Technical design note

Project name	Himley Village, Bicester - Reserved Matters Application		
Design note title	Discharge of Condition 11 - Supplementary Information		
Document reference	27141-HYD-XX-XX-TN-C-0005		
Author	B. Tawton		
Revision	P01		
Date	27 October 2023	Approved	<input type="checkbox"/>

The following Technical Note is to be read in response to LLFA's comments on the Discharge of Condition application reference 23/00207/DISC regarding the site wide surface water drainage strategy for the Proposed Himley Village development site.

TITLE S278 OFFSITE HIGHWAY WORKS STREET ACCESSES LEGAL PLAN	
HYDROCK PROJECT NO. C-27141-C	SCALE @ A1 1 : 500
STATUS DESCRIPTION INFORMATION	STATUS S2
DRAWING NO. (PROJECT CODE-ORIGINATOR-ZONE-LEVEL-TYPE-ROLE-NUMBER) 27141-HYD-XX-XX-DR-D-0160	REVISION P01

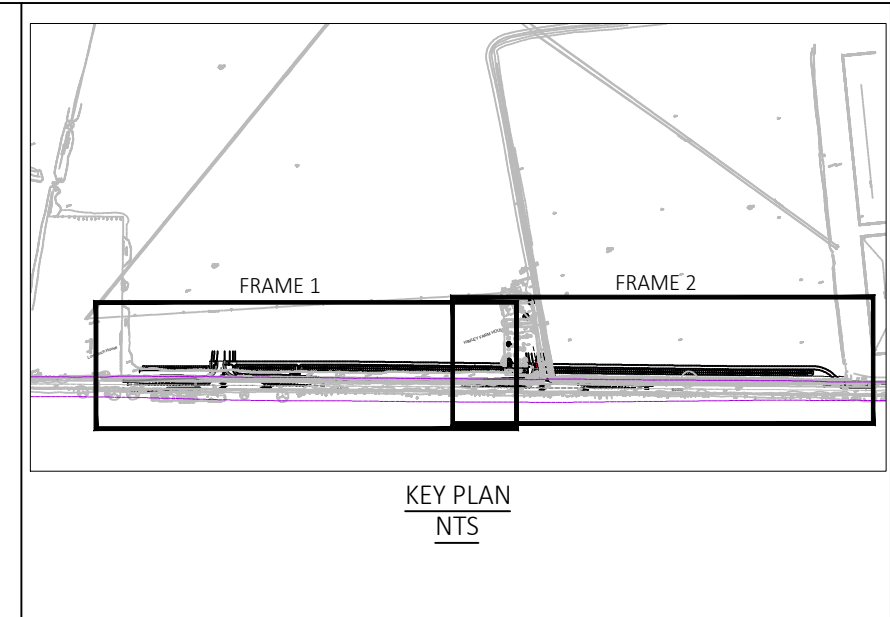
Provide correspondence from highways to confirm the existing ditch has capacity to take the additional hard standing areas, a form of agreement has to be provided to discharge surface water to the existing highways network.

The additional area will be draining to an existing surface water network. Confirm with the use of calculations or correspondence from the relevant party to confirm the existing network has capacity to take additional surface water loads.

Although it is acknowledged that new hardstanding areas are being created with the proposed development, the site currently drains at uncontrolled greenfield rates into the existing ditch network (as established as part of the outline planning approval). The new development will simply continue to discharge into the same network but will restrict rates such that they will be significantly lower than the existing scenario during periods of heavy rainfall.

The site has a riparian right to continue to drain to the existing culverted watercourse (Middleton Stoney Road ditch) and as the Surface Water will be managed to pre-development run off rates, there will be no increase in flows post development.

On the above basis, there is no requirement for a form of agreement to be provided to discharge water to the existing surface water network in order to clear Condition 11 of the outline planning consent.

As established in the approved outline planning application, the existing ditch already receives surface water runoff from the proposed development site, via the existing ditch network, and thus any runoff from the development will not be classed as "additional area", but existing area which will be intercepted and attenuated close to source, before being discharged to the ditch at a restricted rate.

On the basis that no additional area is draining to the existing offsite network at rates set out within the approved flood risk assessment, there is no requirement to provide detailed calculations of the offsite network under in order to clear Condition 11 of the outline planning consent.
